## DESIGN EXCELLENCE PANEL MEETING

**PROPERTY:** 100 Mount Street, North Sydney

**DATE:** 7 July 2009 @ 3.00 pm in the Supper Room

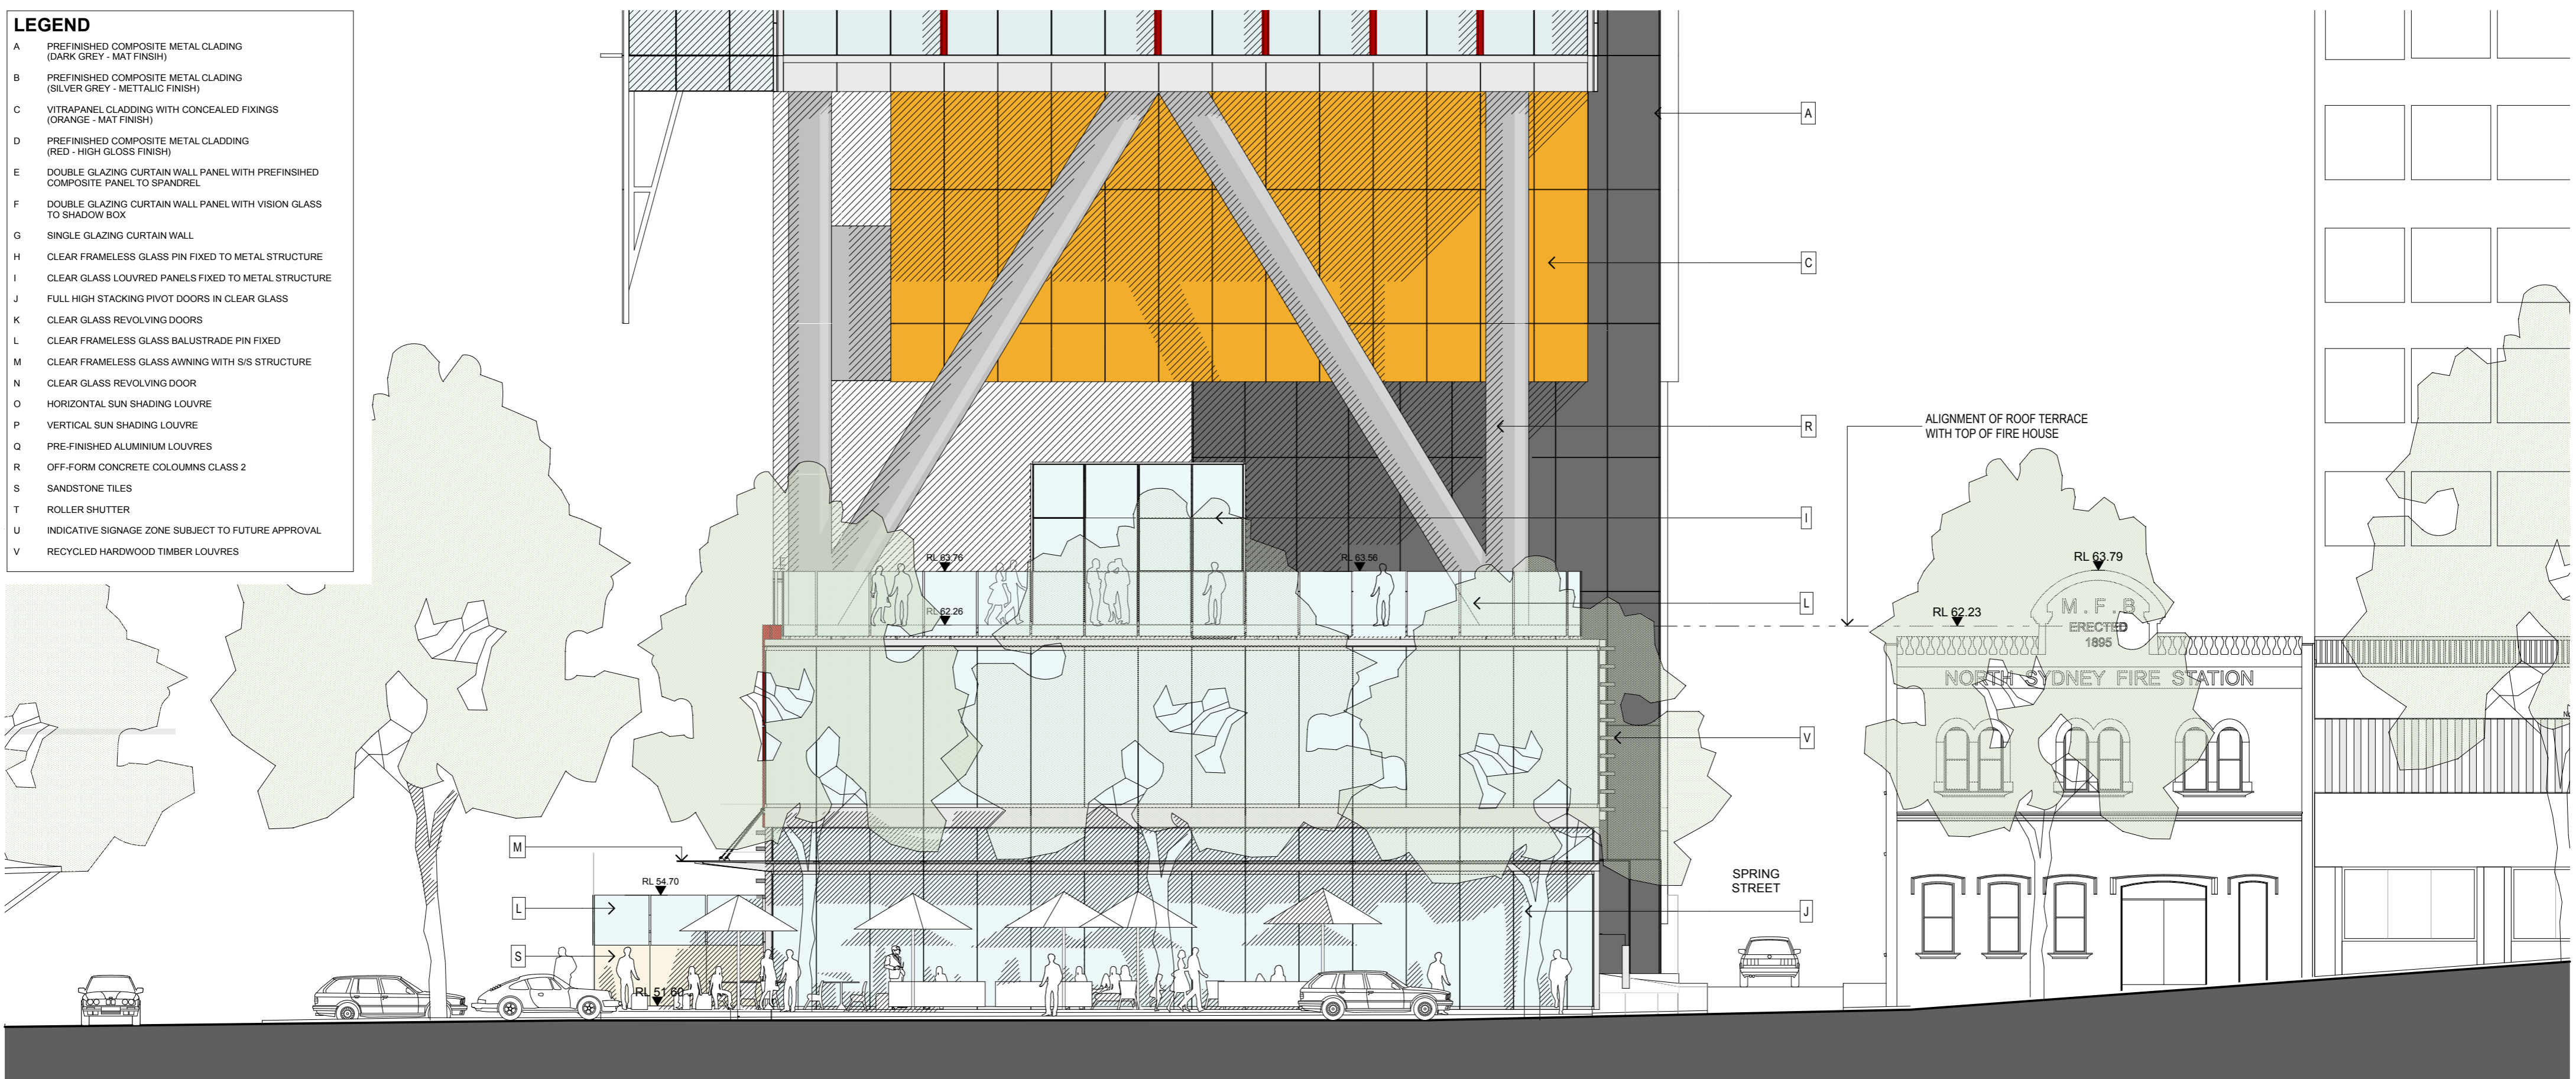
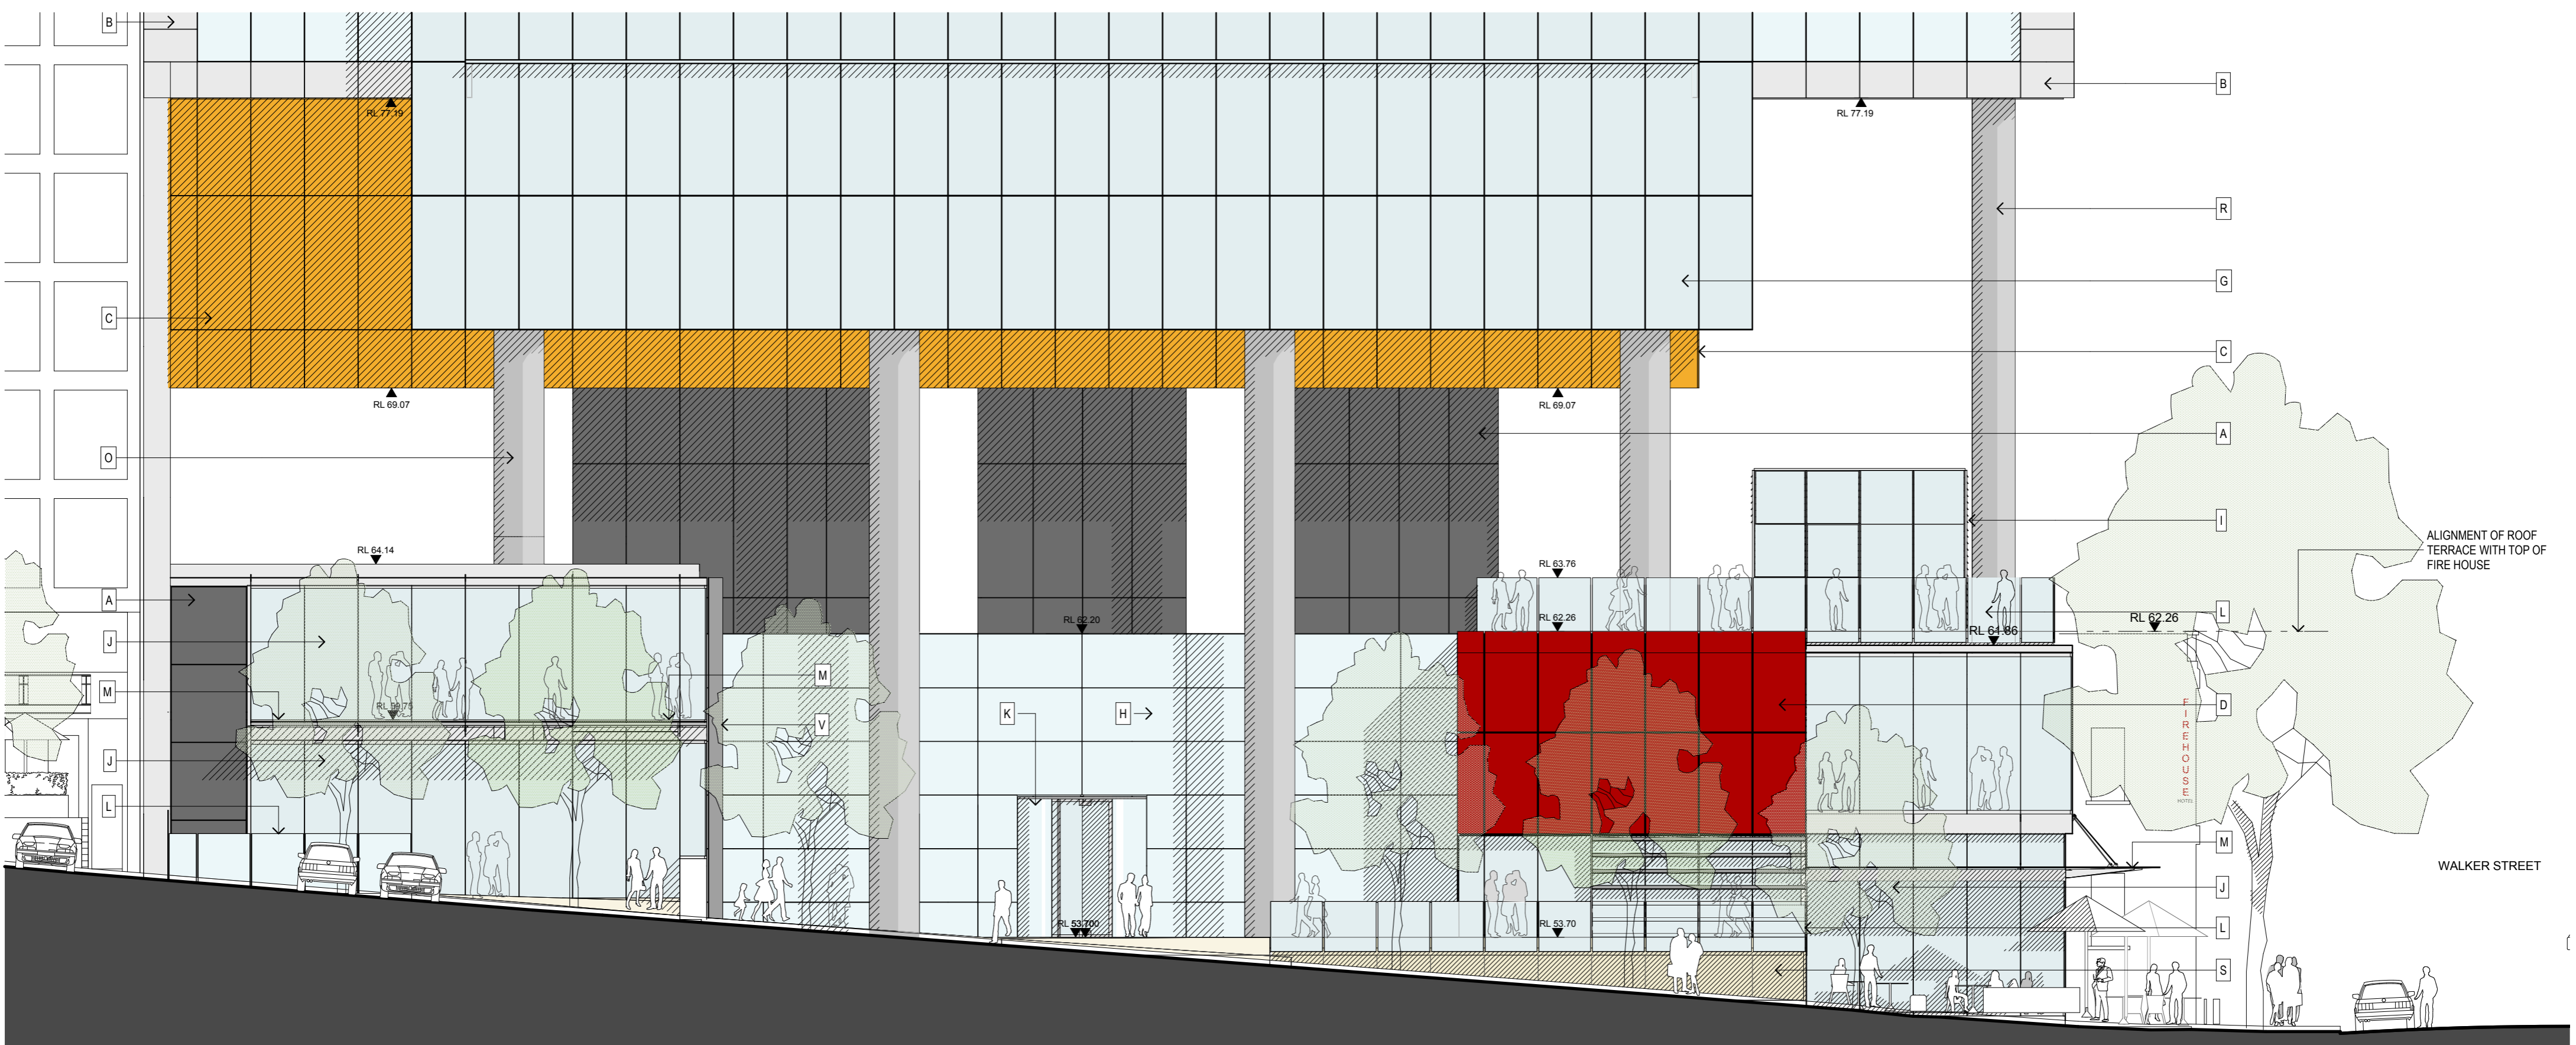
The Panel raised concern about proposed signage on top of the building but was advised that the drawings merely showed the intended location of future signage and that any signs required further development consent with regard to the scale and content of the signs.

The Panel accepts the proposed (non complying) setbacks of the tower from Spring Street and Mount Street, but is strongly of the view that the proposed projection forward of the tower at level 22 on the Walker Street facade should not be permitted.

The Panel also has considerable concern with the setback treatment of the building between levels 8 and 12. The recess above the two levels fronting Walker Street with the very assertive exposed structural frame is inappropriate in this context. This is not justified and is grossly out of scale with the building's setting.
